CITY OF ALBUQUERQUE

December 22, 2017

**RE: Industrial Water Engineering
Grading and Drainage Plan
Engineer's Stamp Date 12/13/17
Hydrology File: C16D006LL**

RE: Industrial Water Engineering G&D Plan Resubmittal (C16D006LL)

SHEET NO.
CG-101

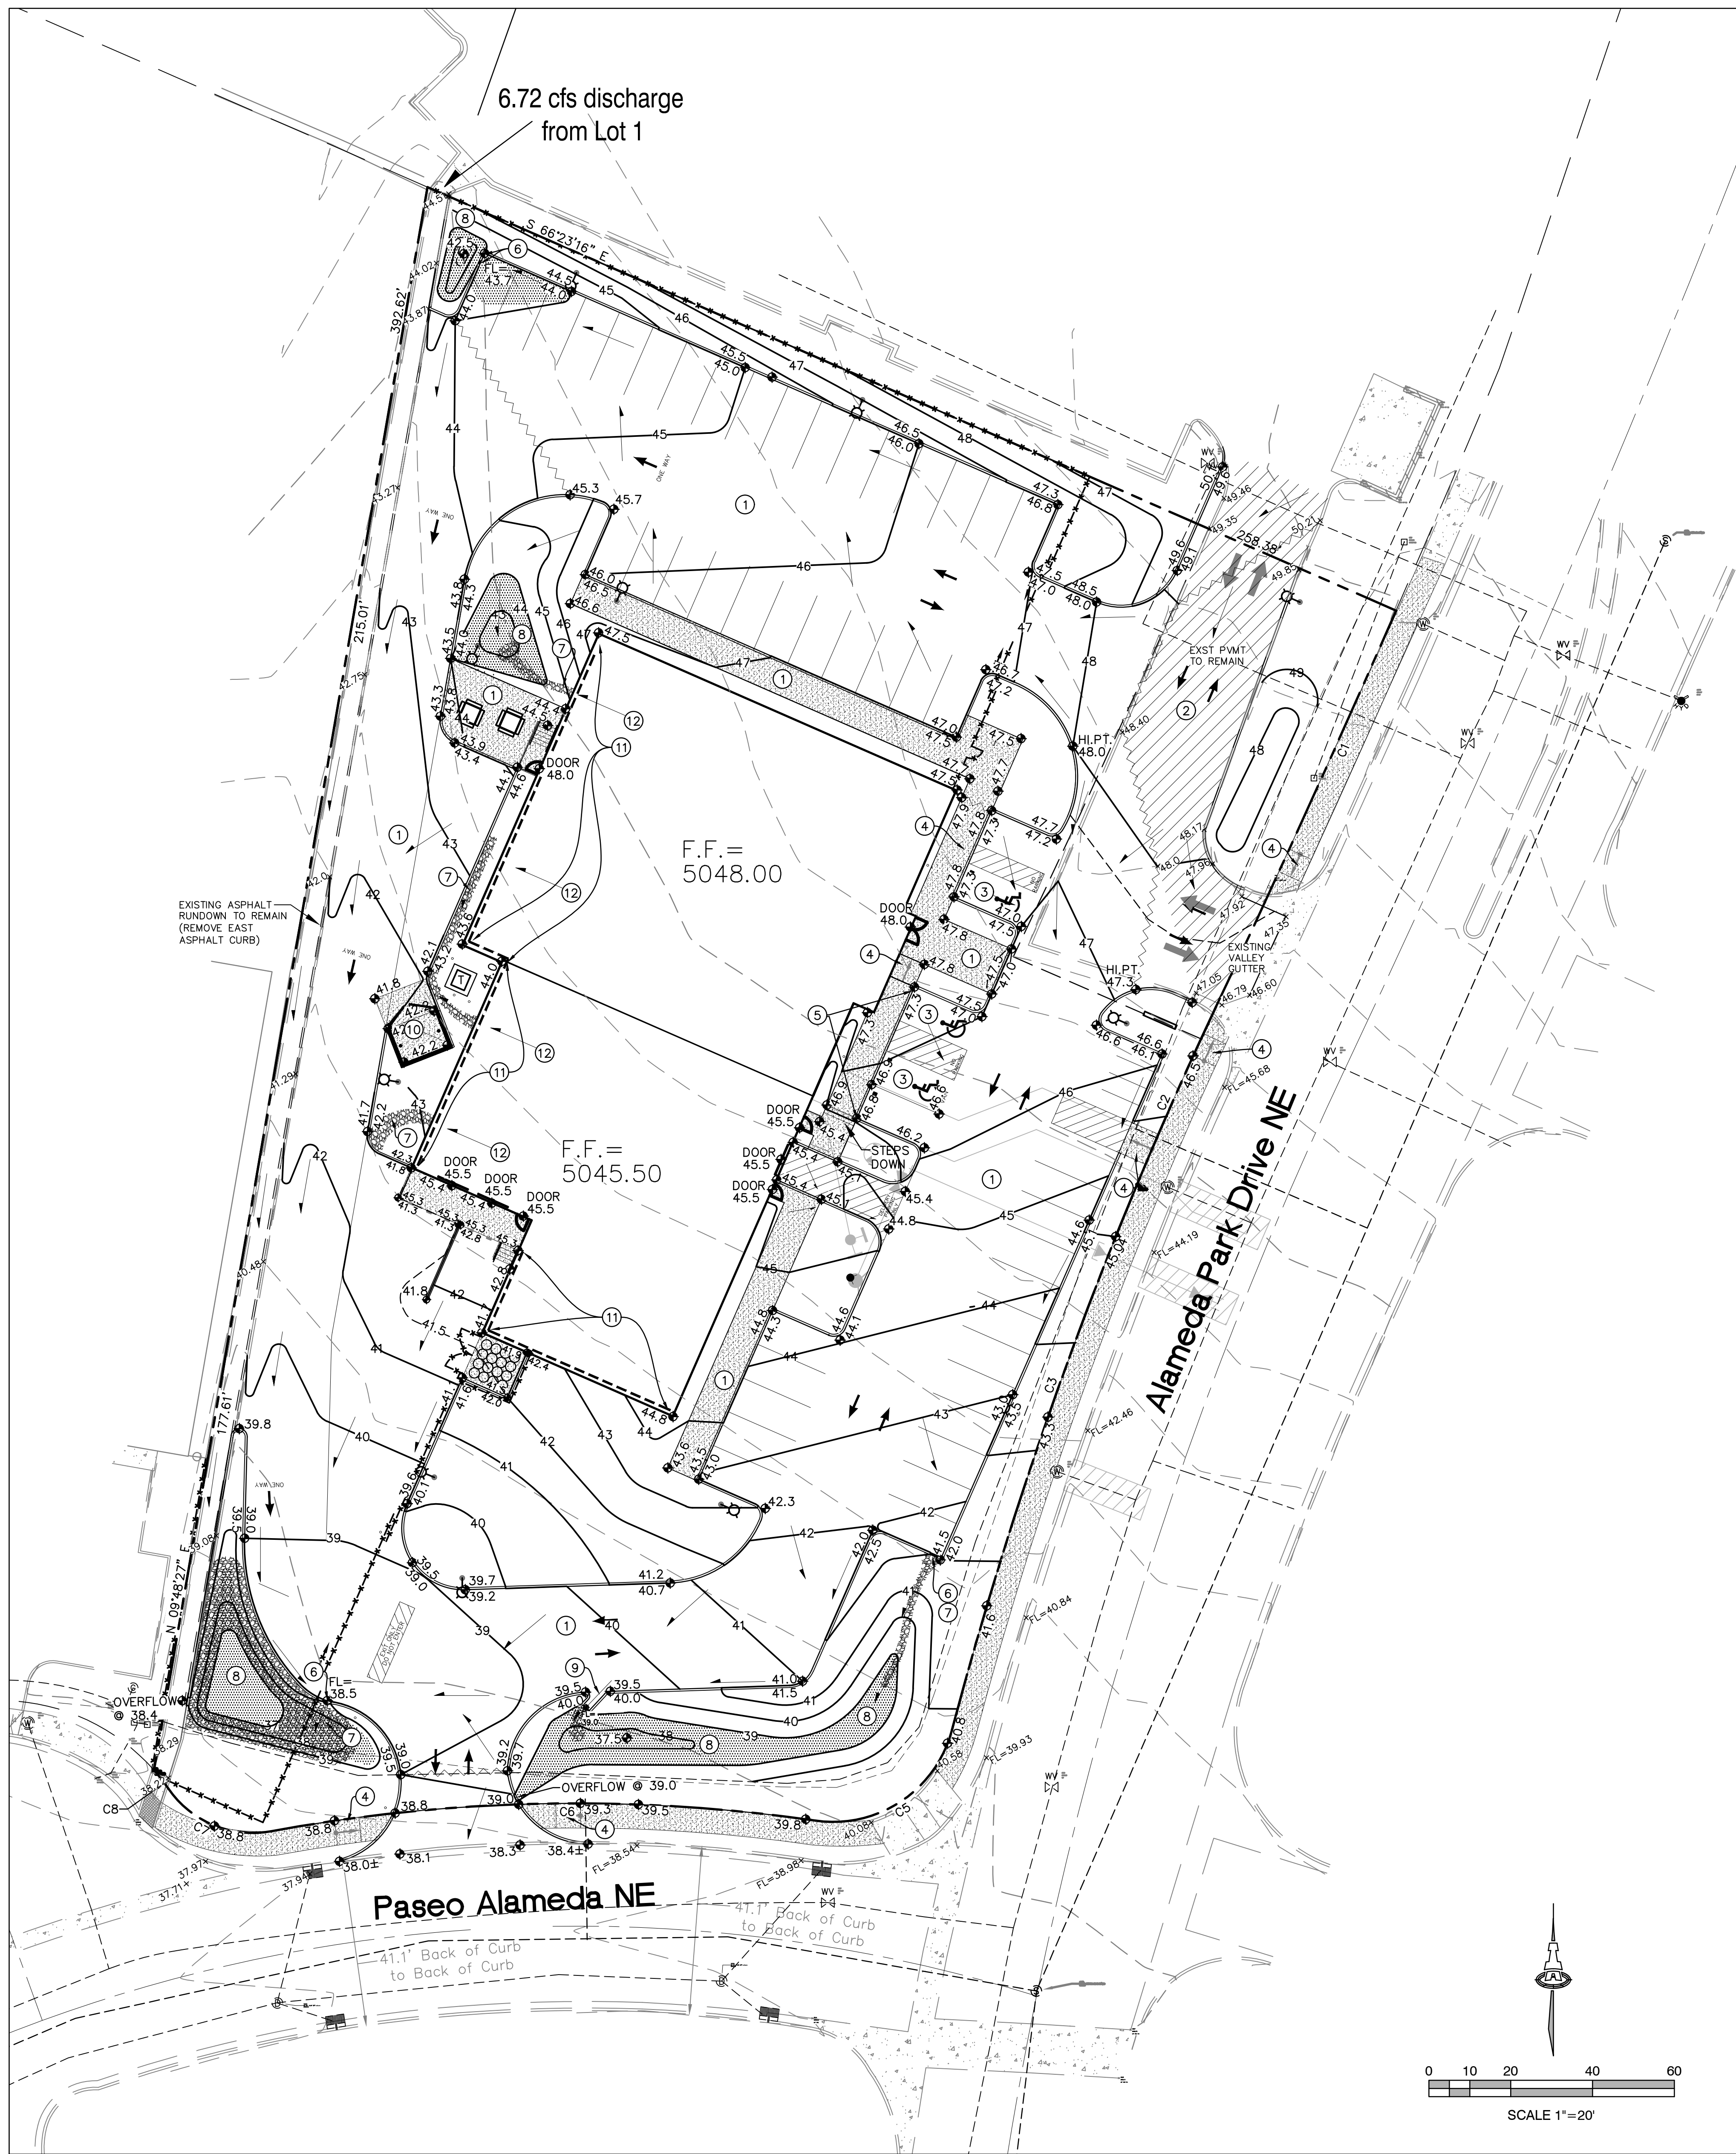
1. Pertinent text has been adjusted to 0.1'..
2. Top of pond, bottom of pond and volumes are called out on sheet CG-101.
3. ESC plan is completed and approved.
4. Draft of Private Facility Drainage Covenant for first flush ponds is provided for review.
5. Hydraulic capacity calculations for the existing sidewalk culvert and existing drainage channel downstream of the overflow from Pond P3 is provided.

We have also added a 0.1' high raised curb on the east edge of the west drainage easement to keep on-site first flush and off-site discharge separated. The off-site discharge passing through the property (6.72 cfs) is handled at a depth of 0.3' along the west curb (see channel calculations attached). The maximum capacity at a depth of 0.4' is 14.5 cfs.
